Recommendation Report for Planning Permission for Works or Extension to a Dwelling

REF NO: Y/47/26/HH

LOCATION: Flints
Hoe Lane
Flansham
PO22 8NP

PROPOSAL: Part single, part two-storey rear extension, and alterations to fenestration.

Proposed Ground Floor Plan

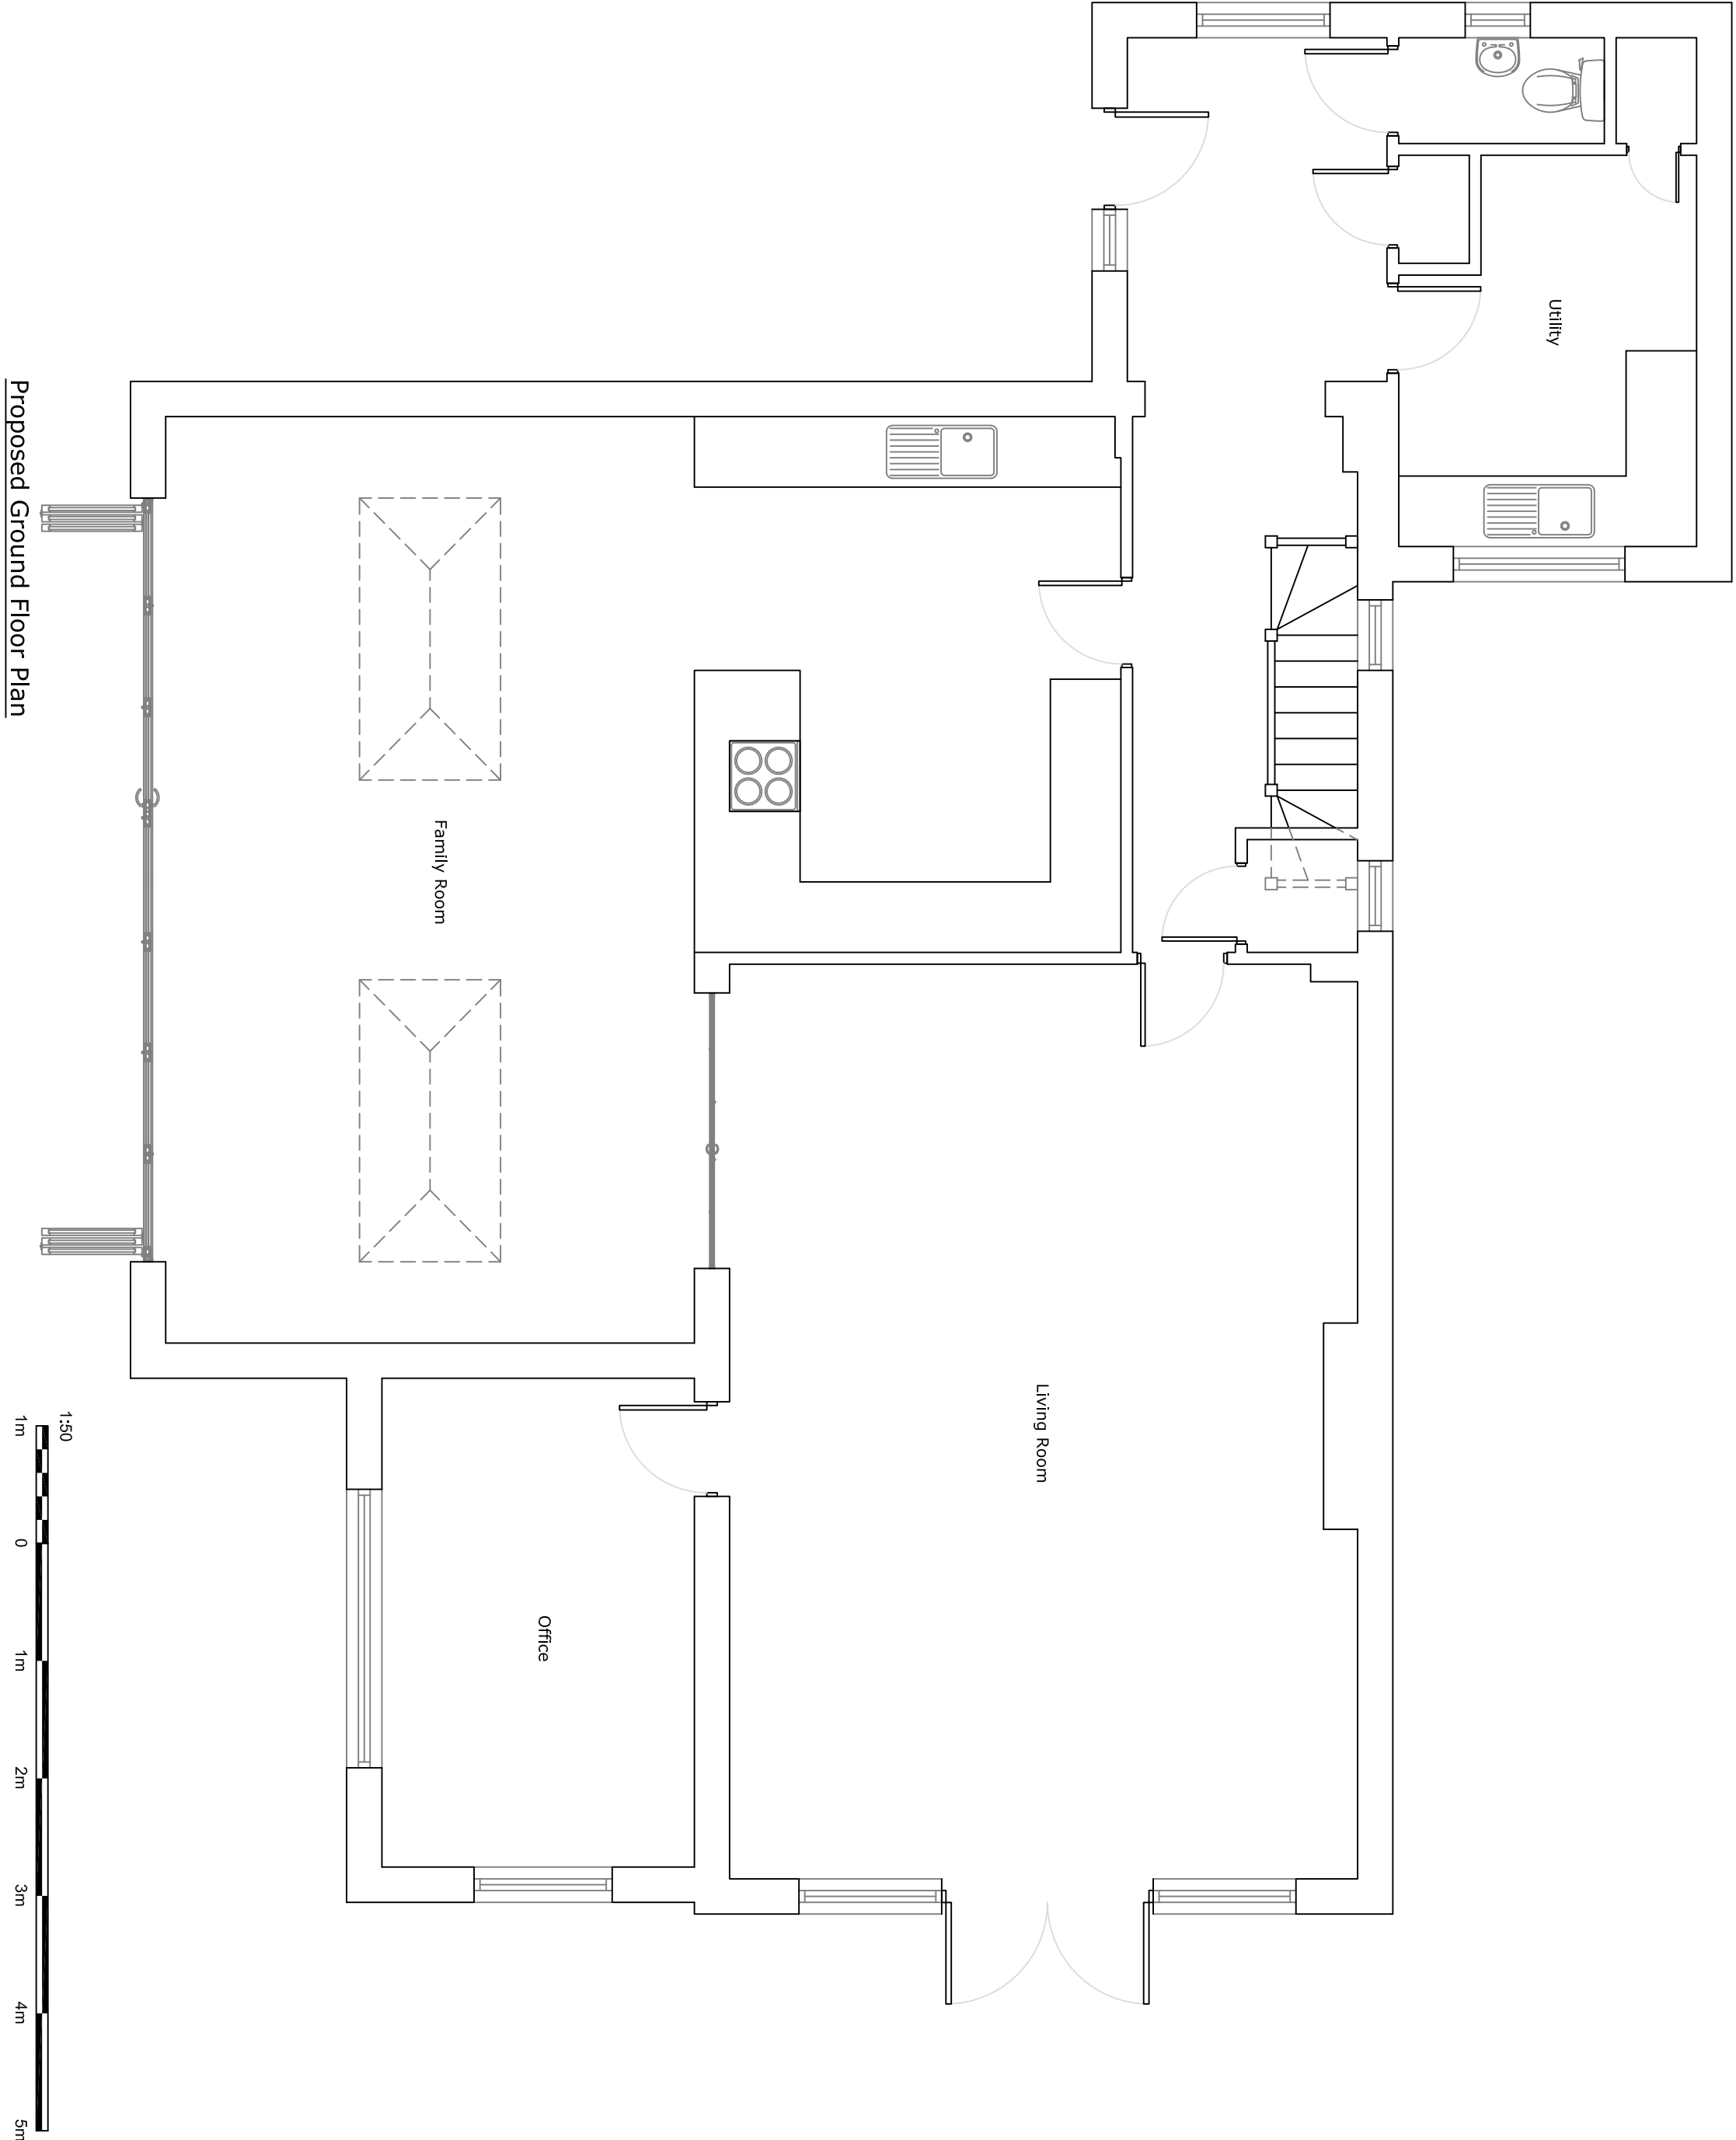
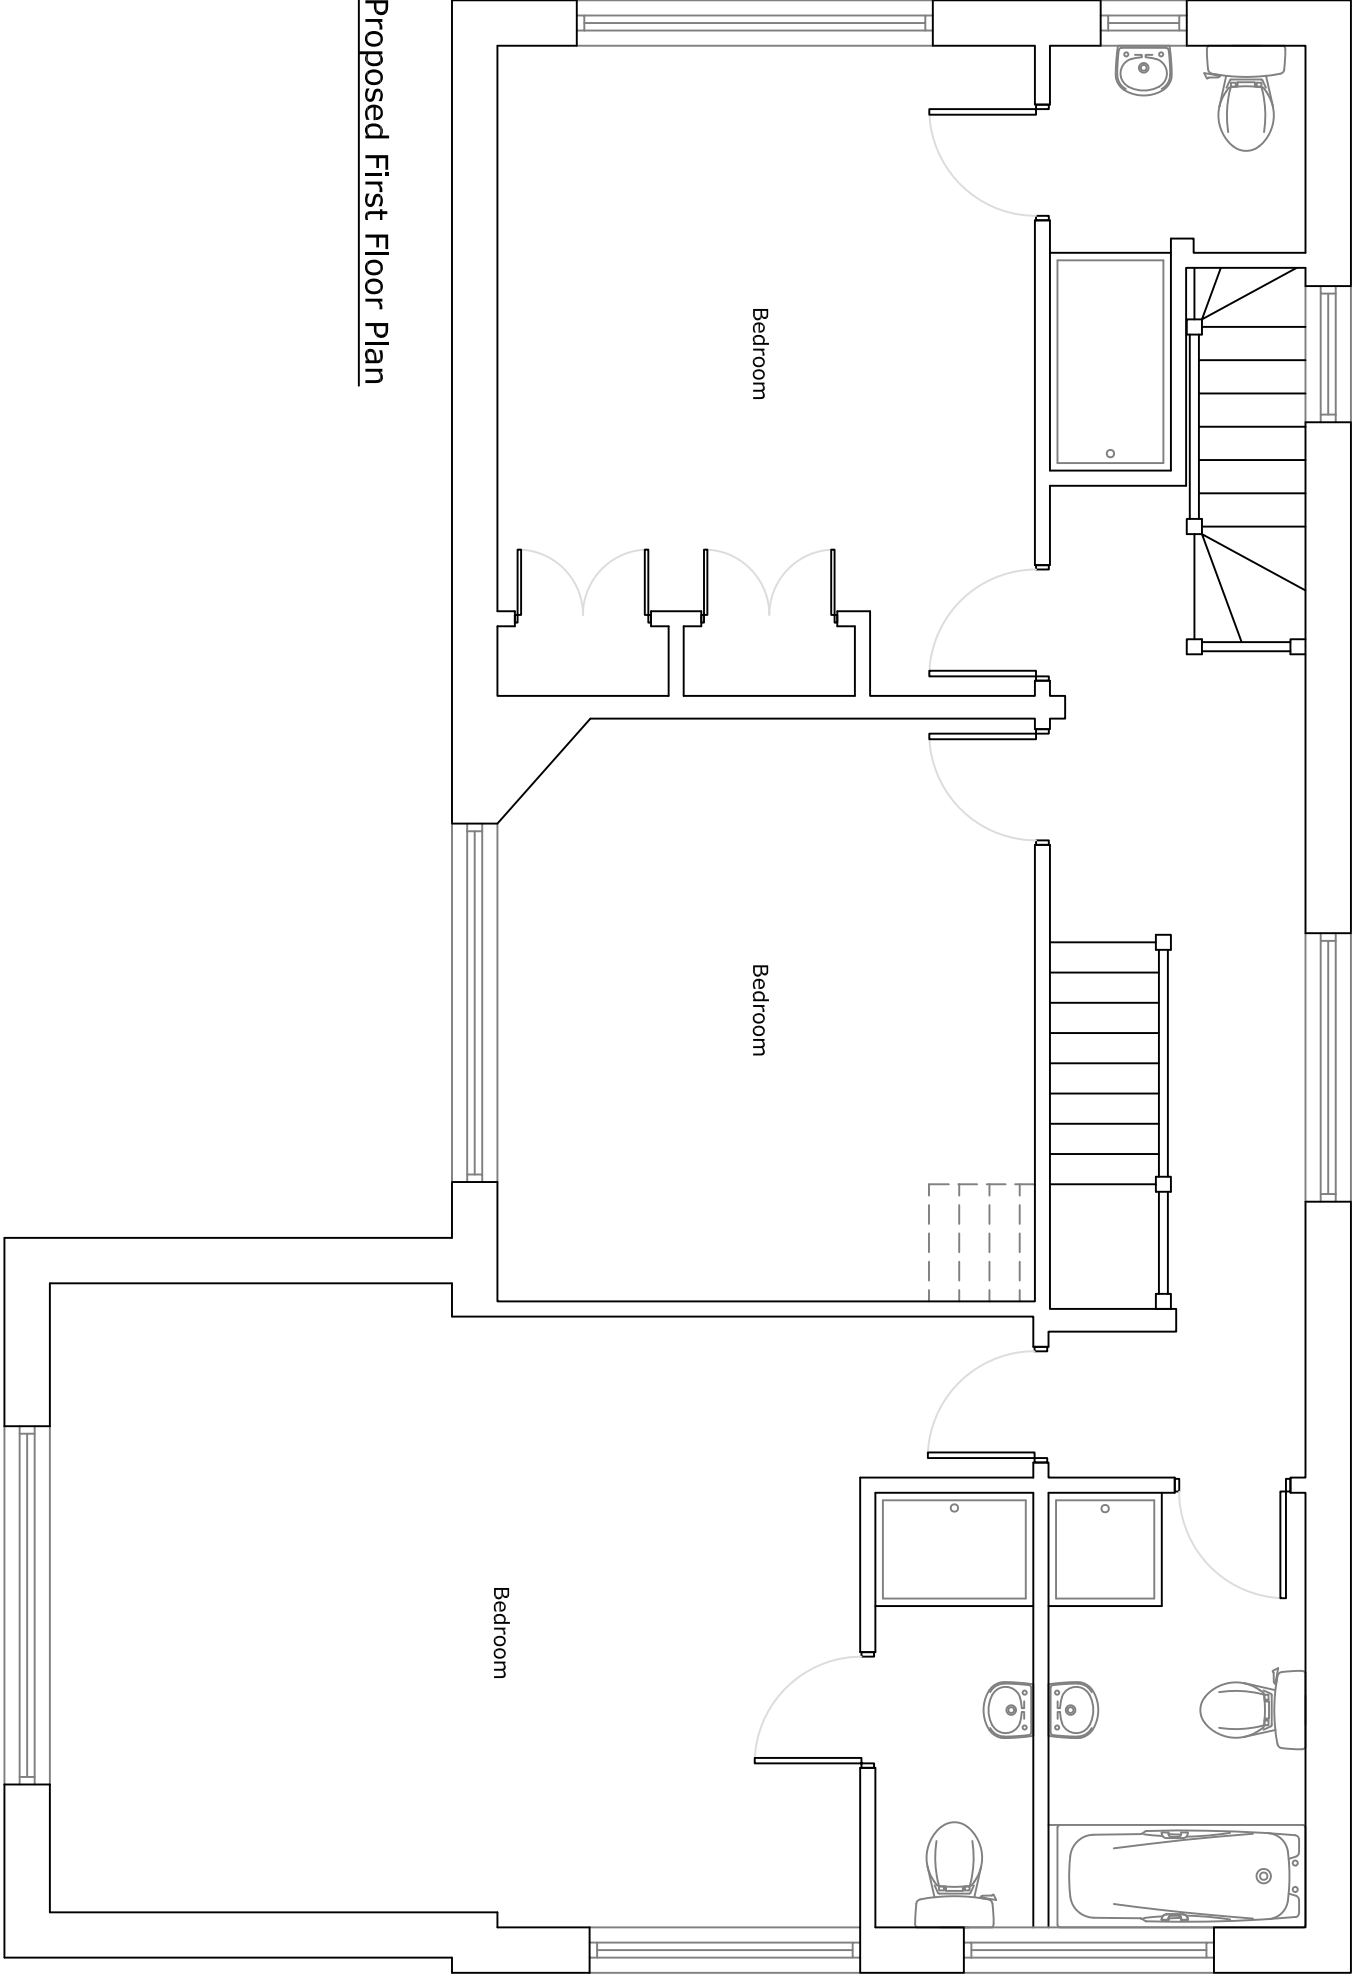
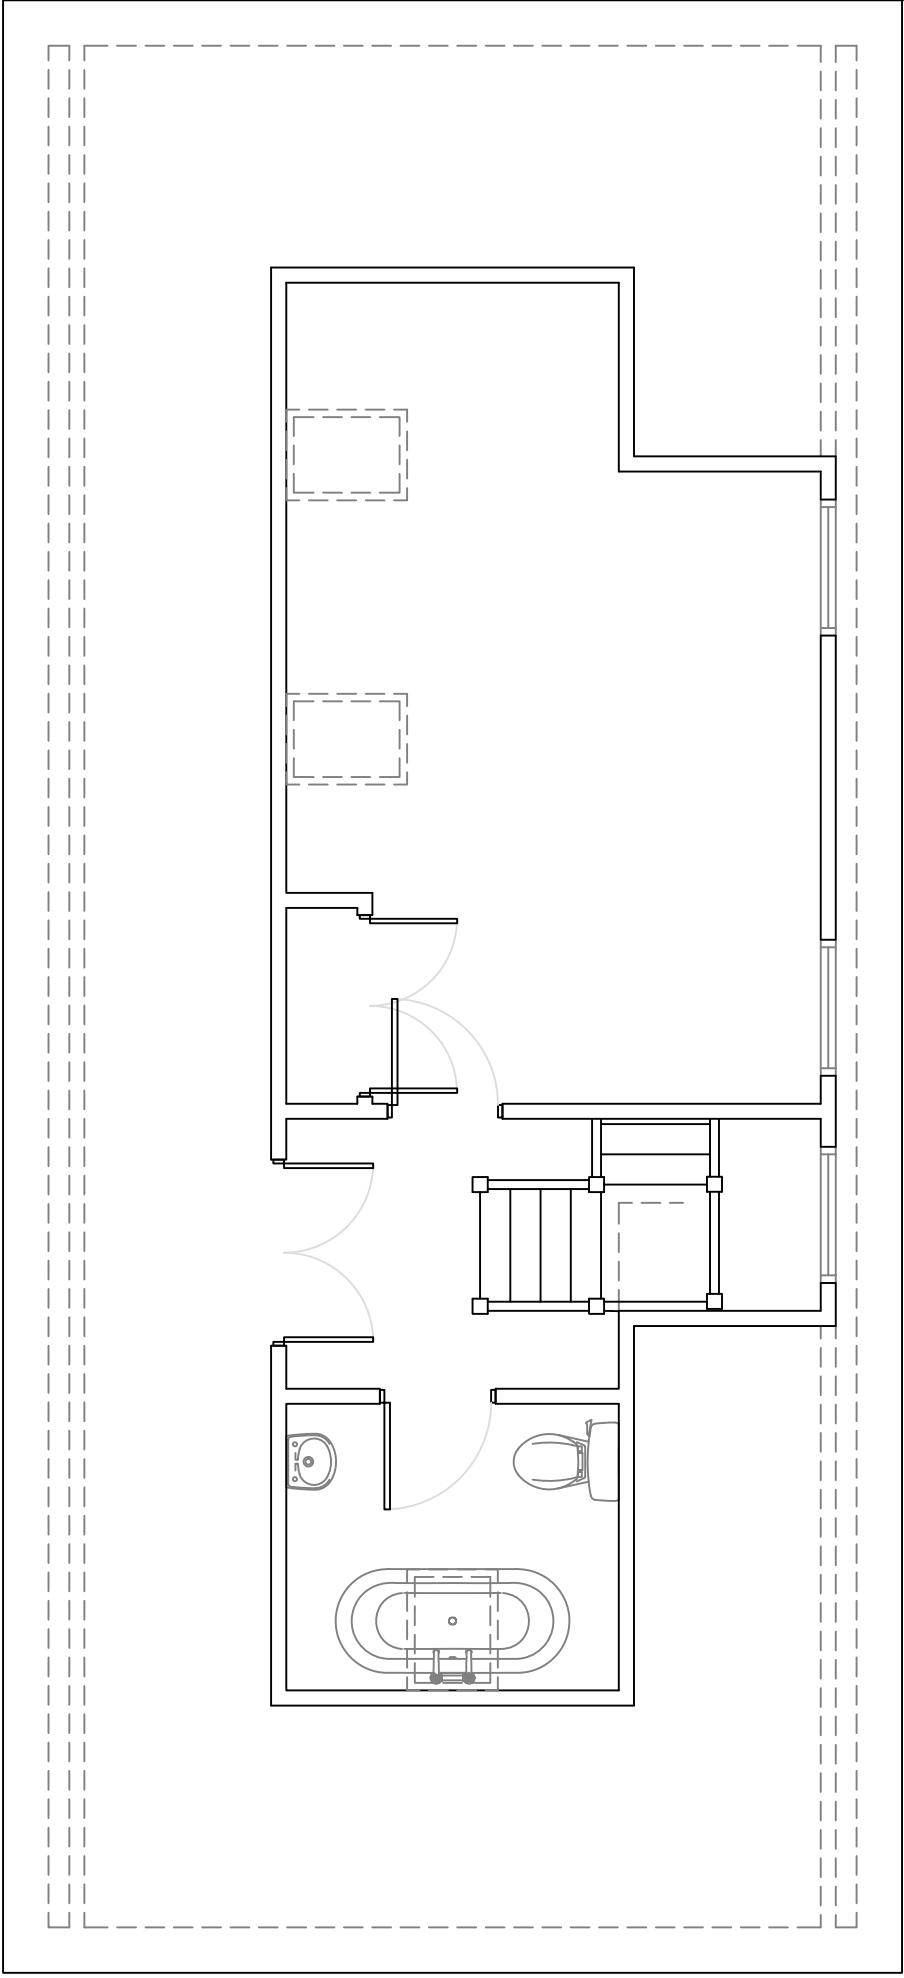
The proposed single-storey rear extension would measure approximately 4.8m in depth and 8.5m in width, partially adjoining the existing rear projection. It would have a flat roof form with a maximum height of approximately 3.3m, inclusive of lantern roof lights. External materials would comprise brickwork and flint to match the existing dwelling, in accordance with the guidance contained within the Arun Design Guide (ADG).

The first floor extension would be sited approximately 6m from the boundary with the north (side) neighbour, Bonhams. Given the siting and scale of the proposed extension, this element would not result in any overshadowing or overbearing impacts to neighbouring properties. Fenestration is proposed within the eastern elevation of the extension at ground and first floor levels. The outlook from this fenestration would not be dissimilar to the views available from the existing ground and first floor level fenestration within the eastern elevation, and the proposal would not result in additional overlooking or loss of privacy.
